Charlotte Department of Transportation

Memorandum

Subject: Rezoning Petition 08-119: Located on the southeast corner of South Mint Street and Lincoln Street (*revised 9/17/08*)

ILLUSTRATIVE SITE PLAN

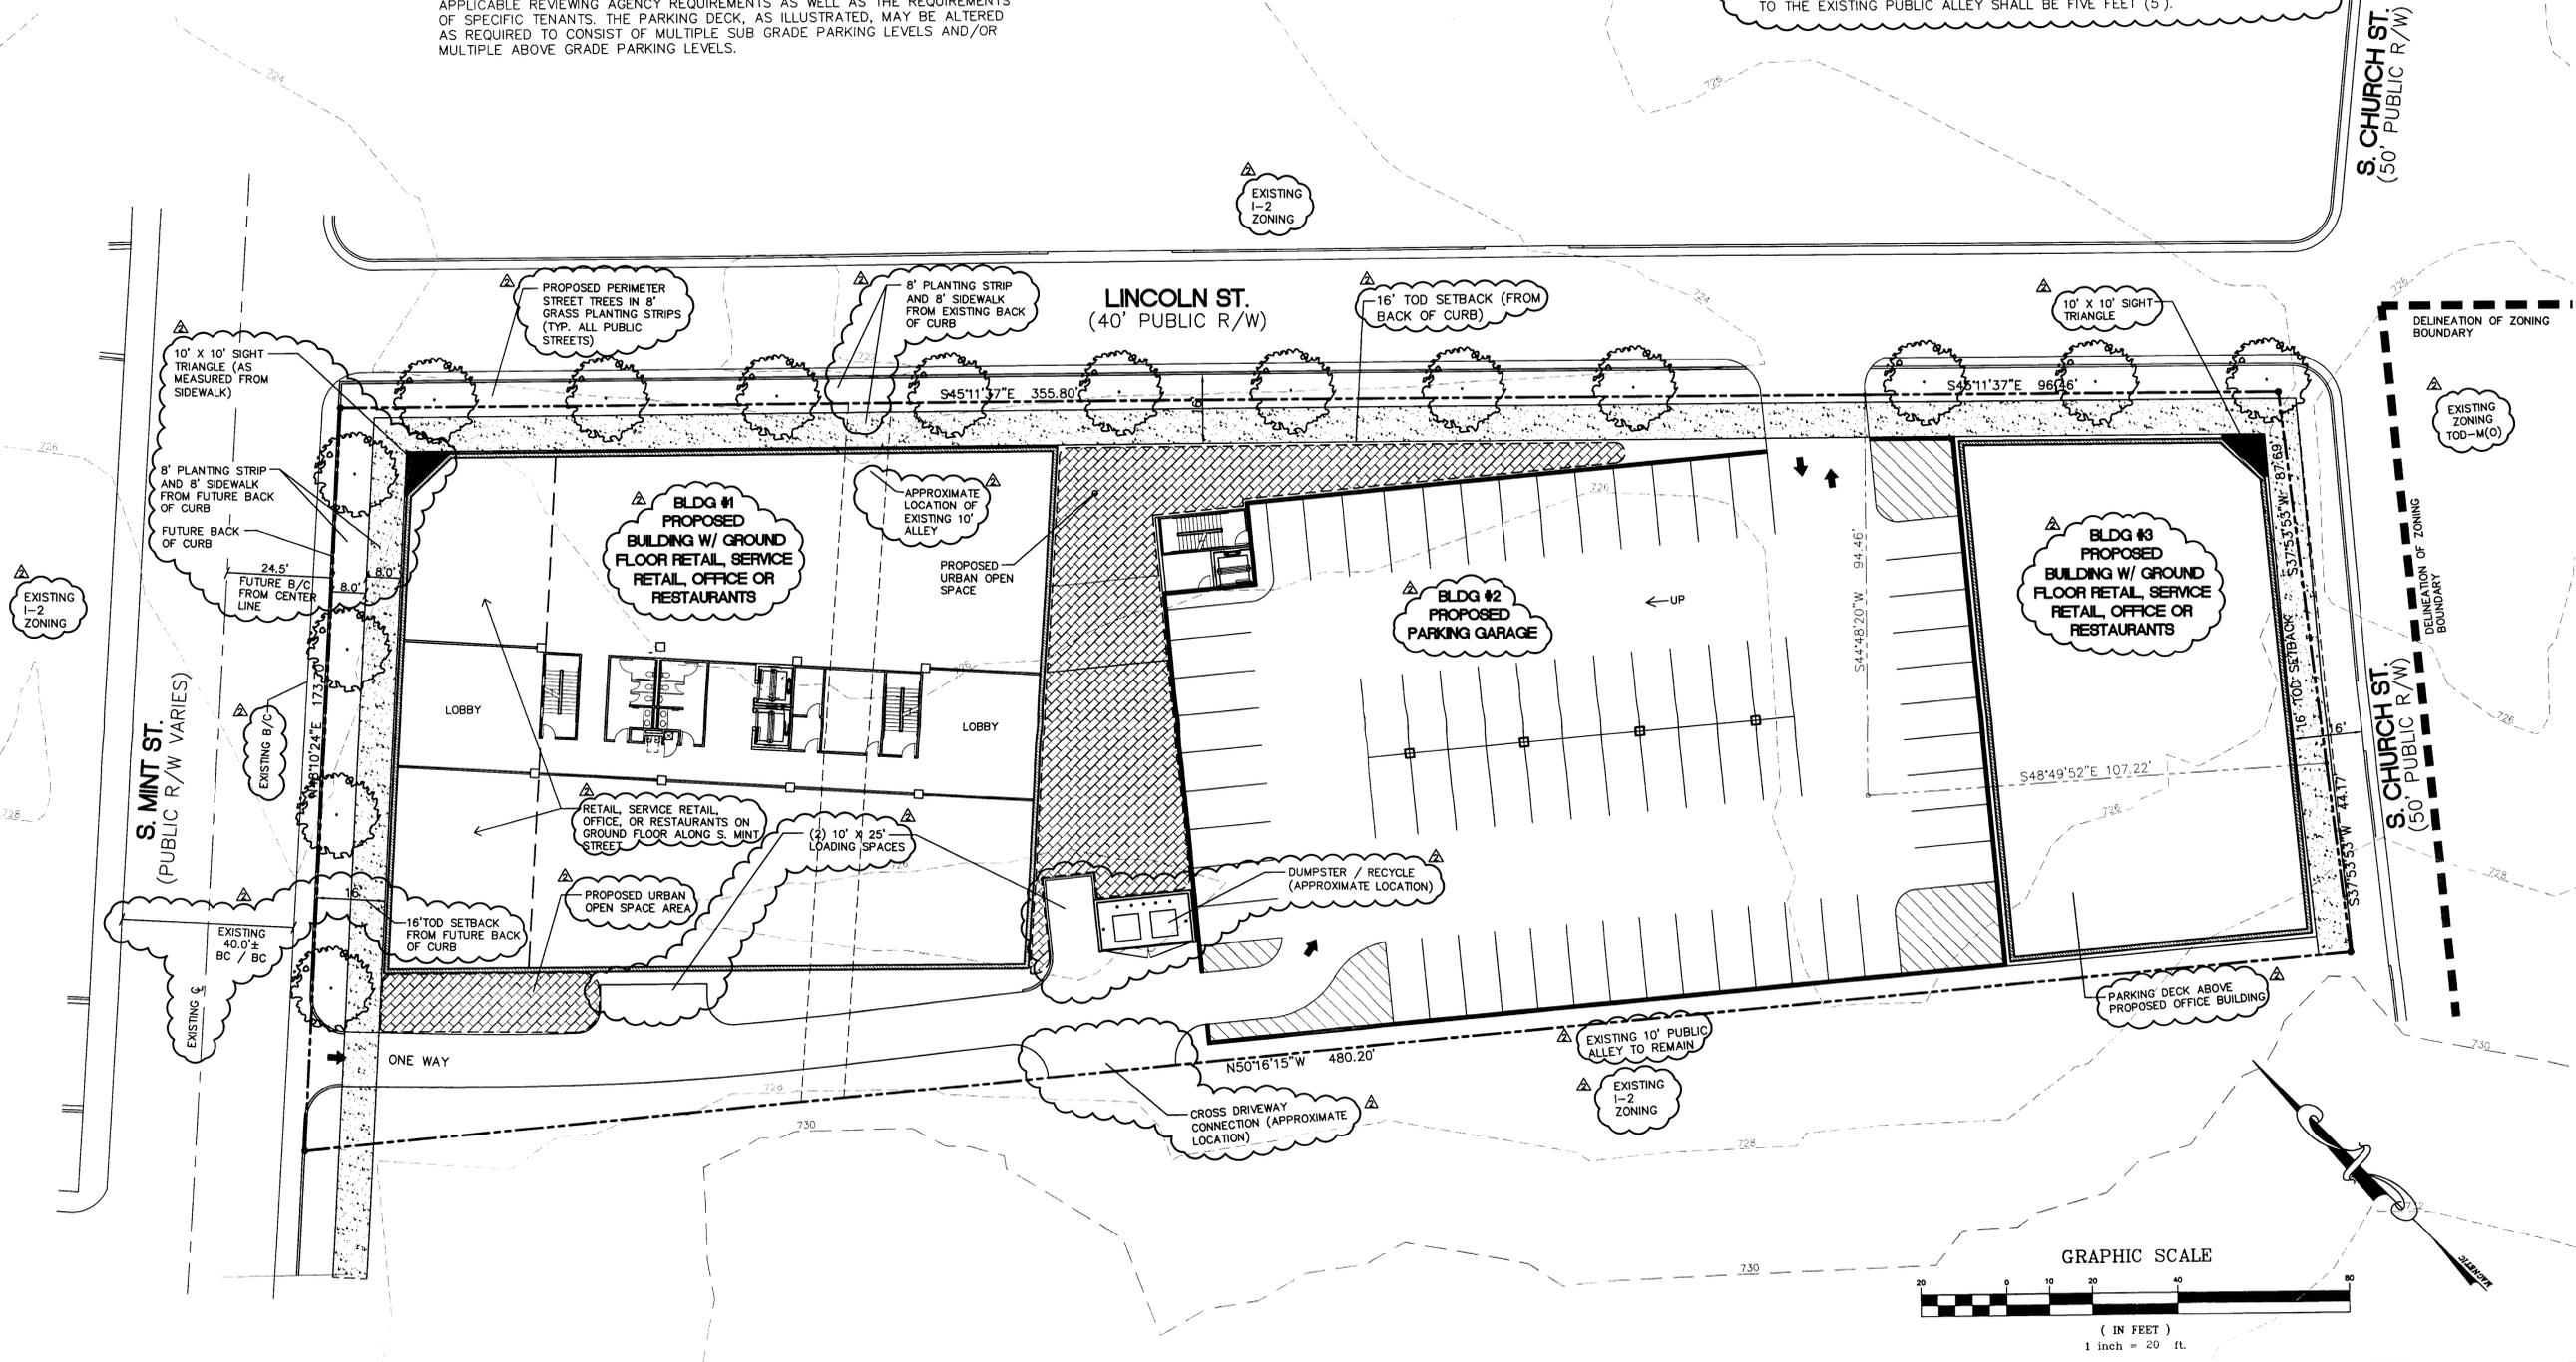
1. Access to the waste collection facilities need to be further clarified. As shown it appears that waste collection vehicles will enter from South Mint Street and exit to Lincoln Street through the 1st level of the parking deck. Although we have previously commented on this issue, it will be addressed in during the building/driveway permit (urban review) process as generally noted in conditional note 13.
